Ribble Valley Borough Council
Housing & Development Control

Your ref: 3/2022/1034
Our ref: D3.2022.1034
Date: 24th January 2023

Application no: **3/2022/1034**

Proposal: **Additional usage to commercial property from E usage to E(d).**

Proposed Site Plan - 1:500

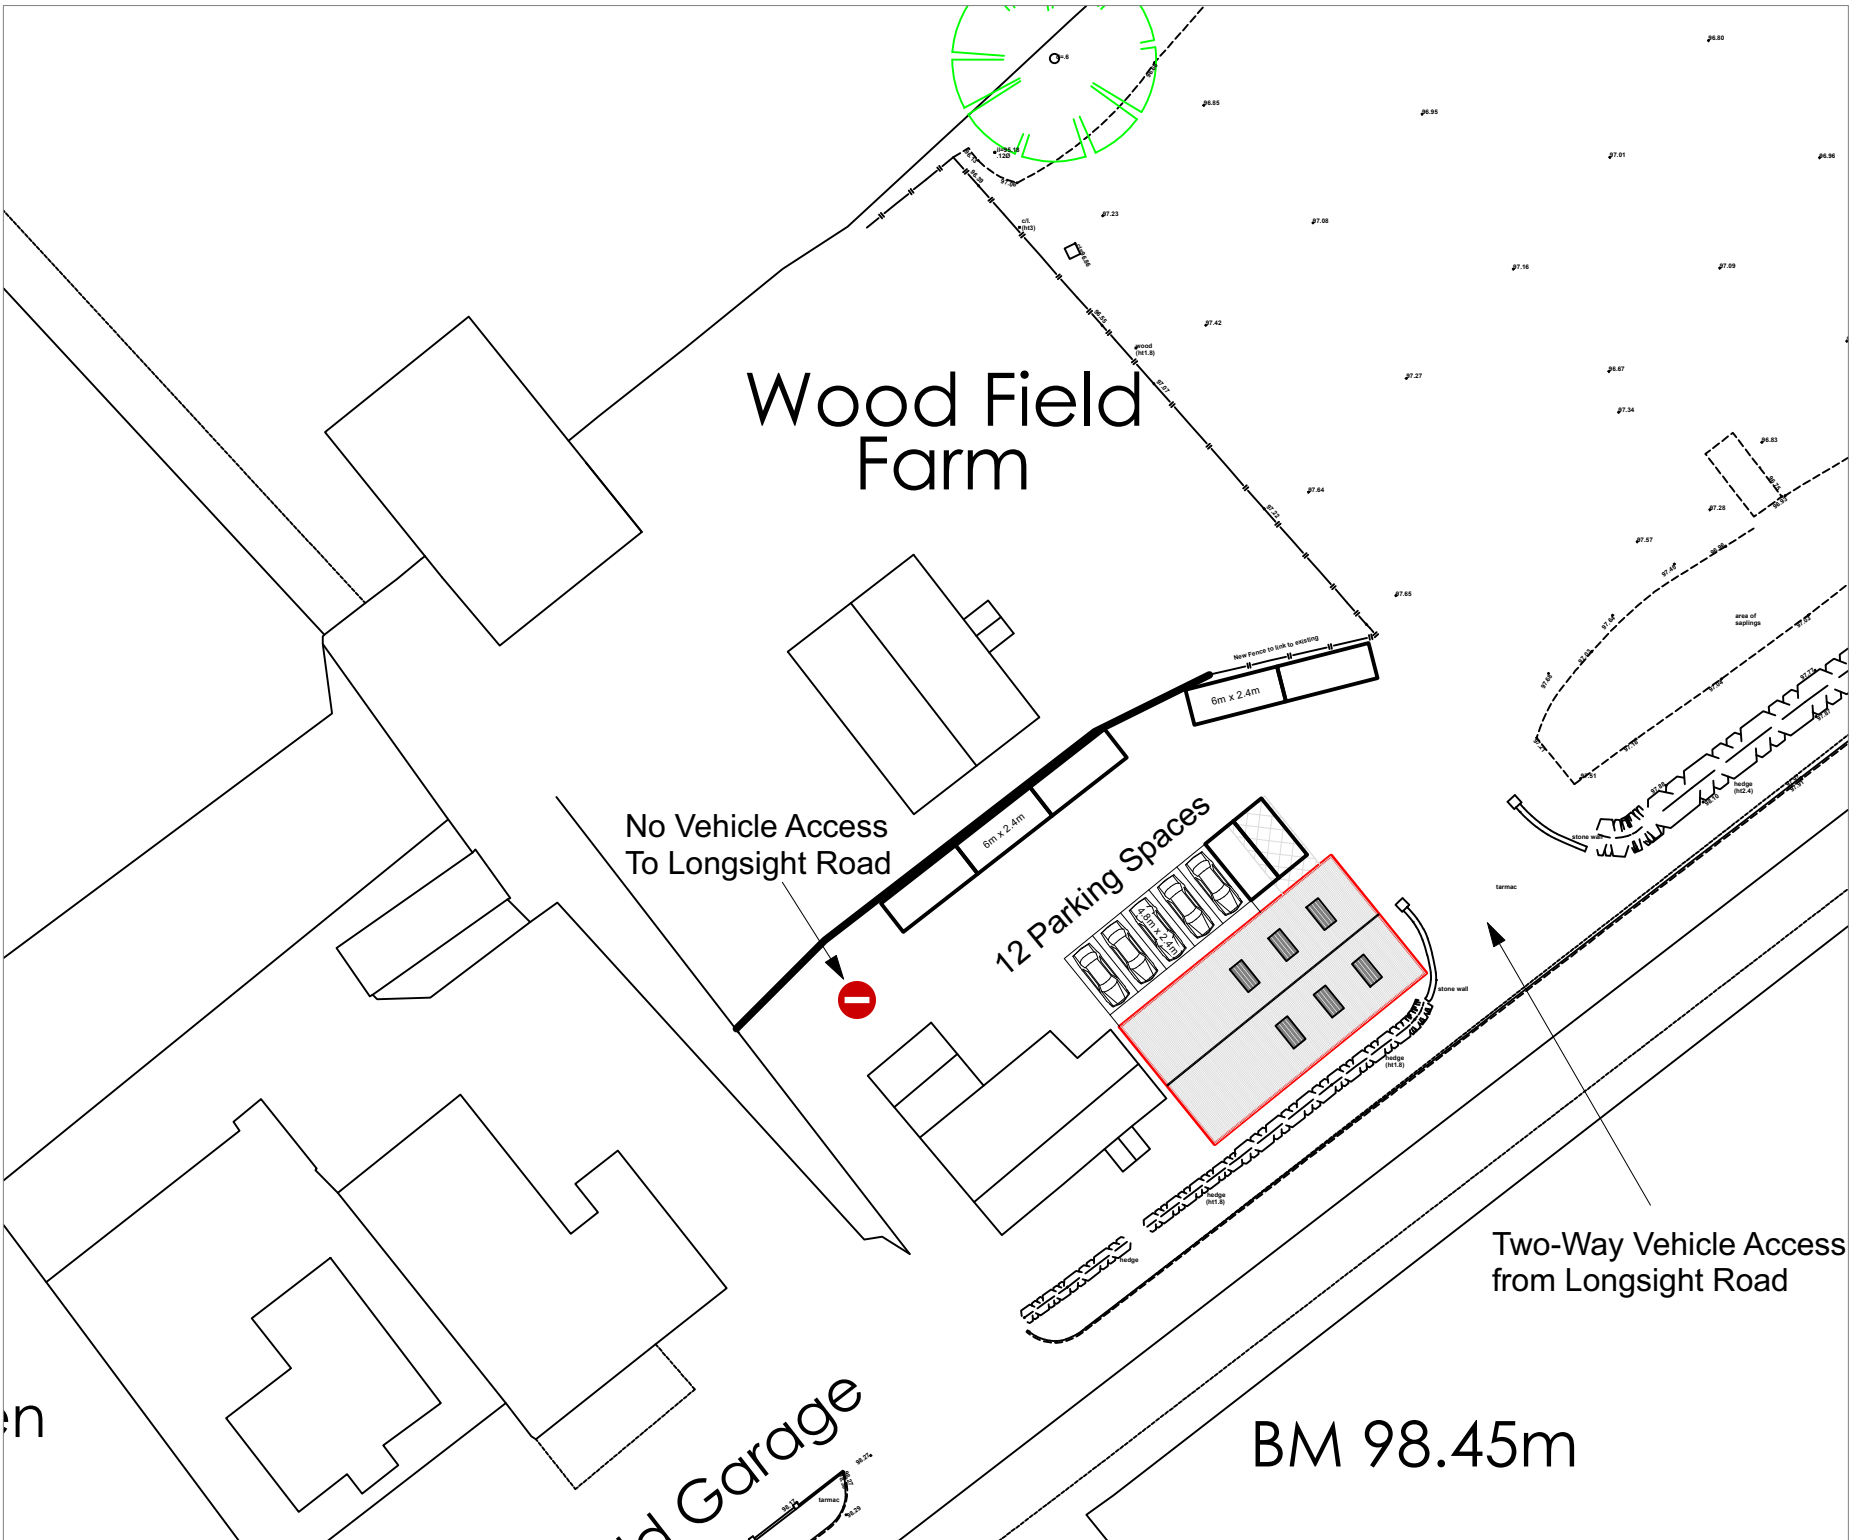
The LHA have reviewed the supporting documents and require further information as to how the site will be accessed. This is because the site can be accessed via two shared accesses. One of the accesses currently serves the Recycling centre and "Wade Site Office," while the other serves Woodfield Garage.

Therefore, the LHA require further information as to whether a one-way system will be implemented to incorporate the use of both accesses when visiting the site. Should this be the case, the LHA advise that the "In" access should be the one which currently serves the Recycling centre and "Wade Site Office," so that vehicles entering the site can clearly view other vehicles exiting their respective internal accesses.

If only one access will be used, the LHA will require that the disused access is stopped up internally to prevent road users from using the access and to prevent confusion.

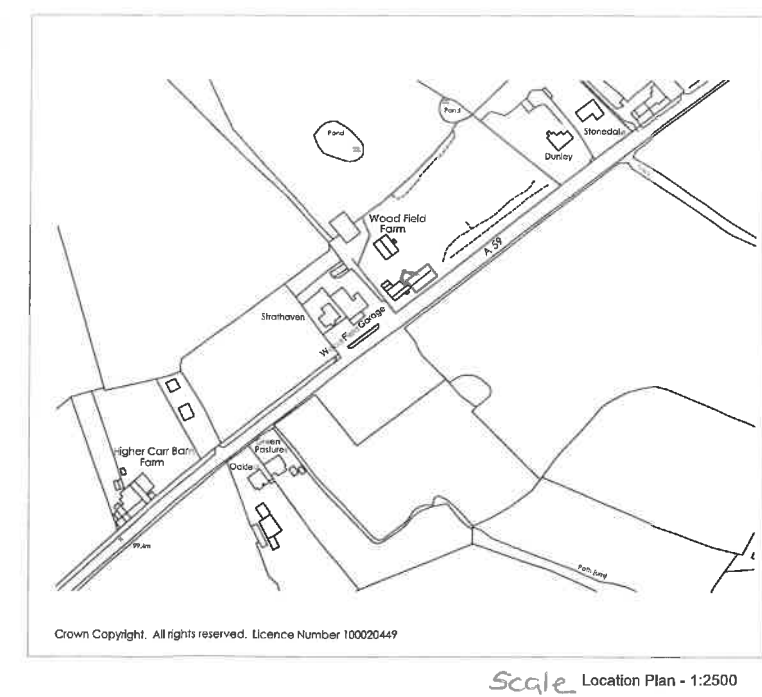
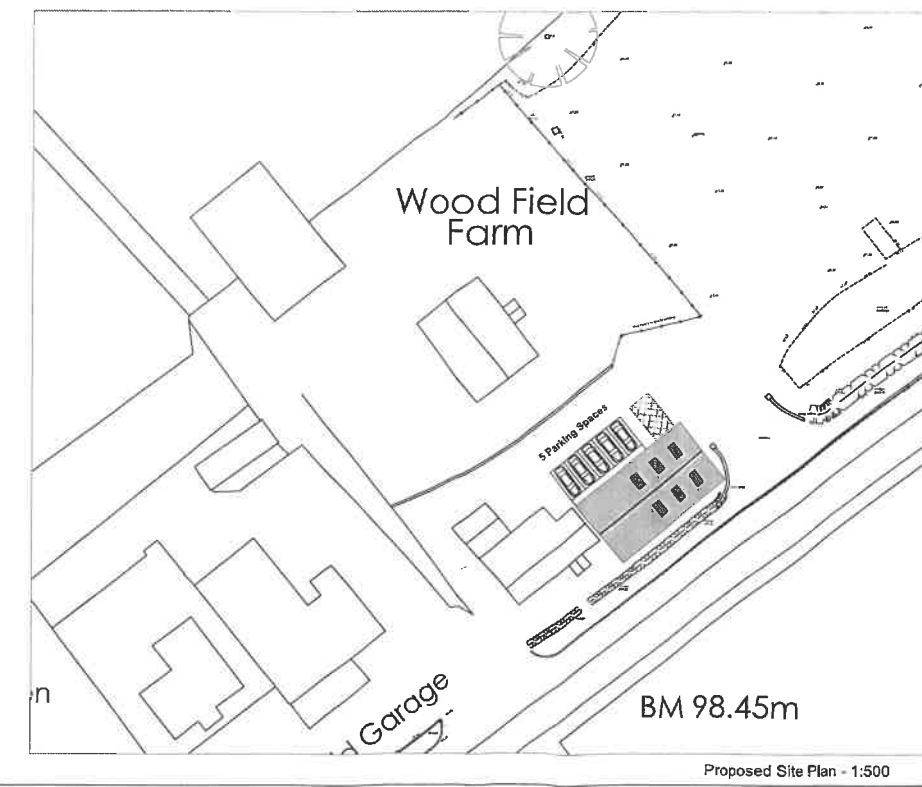
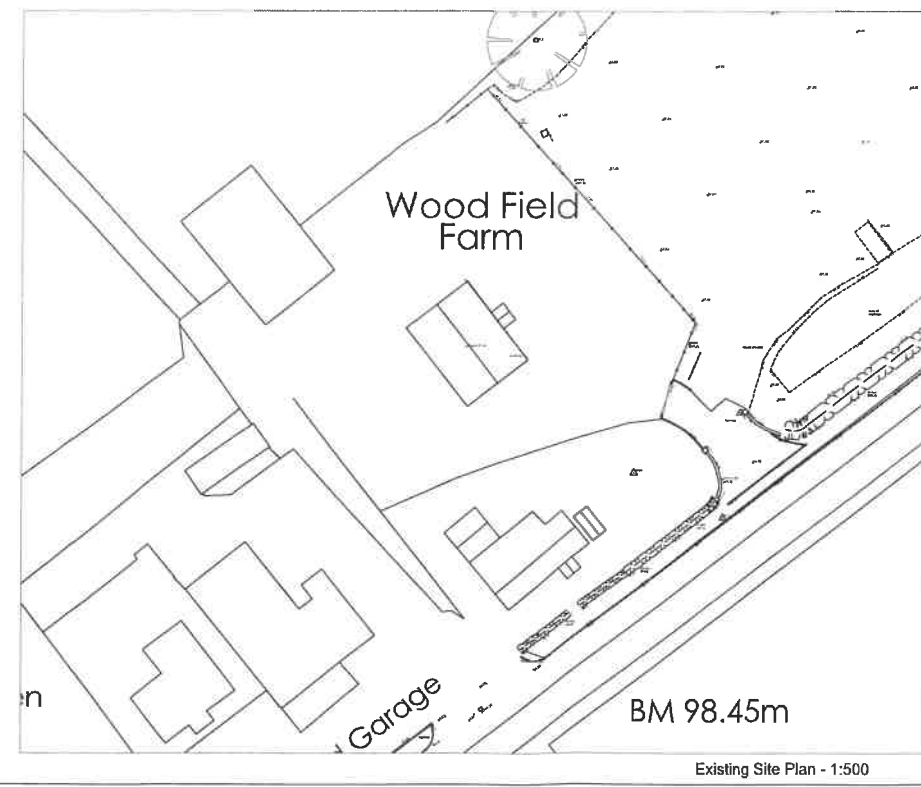
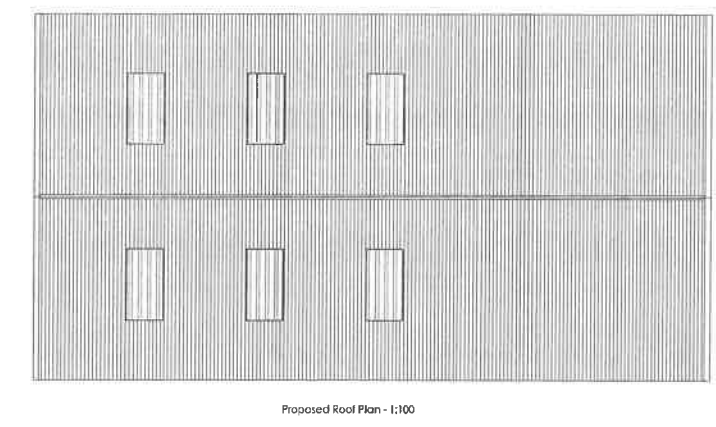
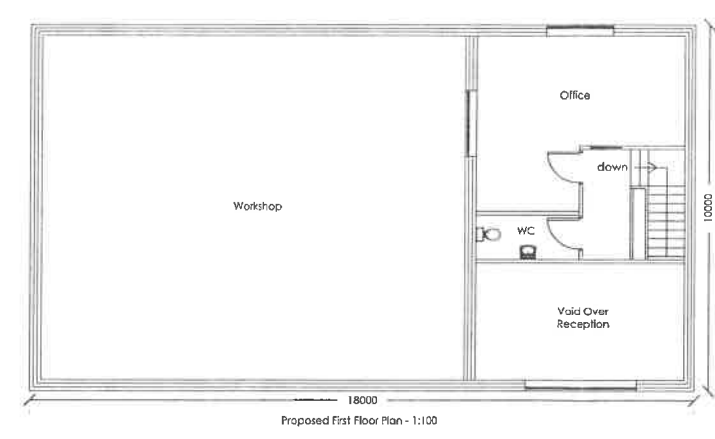
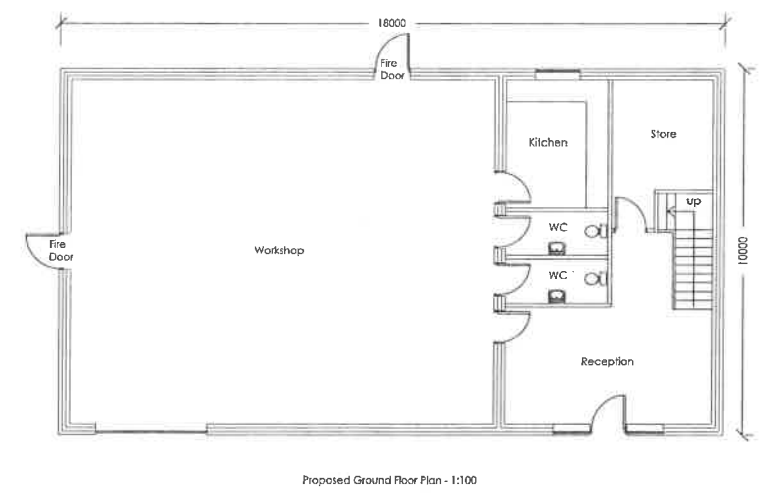
The LHA have reviewed GHA drawing number Wade/133/2970/01 titled "Existing Kennel Building Plan and Elevations; Proposed Commercial Building Plans and Elevations; Existing and Proposed Site Plans; Location Plan" and are aware that 5 car parking spaces will be provided to serve the gym.

To ensure that the proposal complies with the LHAs parking guidance as defined in the Joint Lancashire Structure Plan, the LHA require further details regarding the internal floor area of the proposal. The LHA remind the Agent that a leisure facility such as a gym is required to provide 1 space per 22 square metres of internal floor space.

Should the proposal not be able to achieve the required car parking spaces, the LHA require an Operation Statement detailing the maximum number of staff and customers

Any additional spaces which are required to provide for the proposal should not compromise the car parking spaces for the existing commercial building, Energy Centre, which is located adjacent to the proposal.
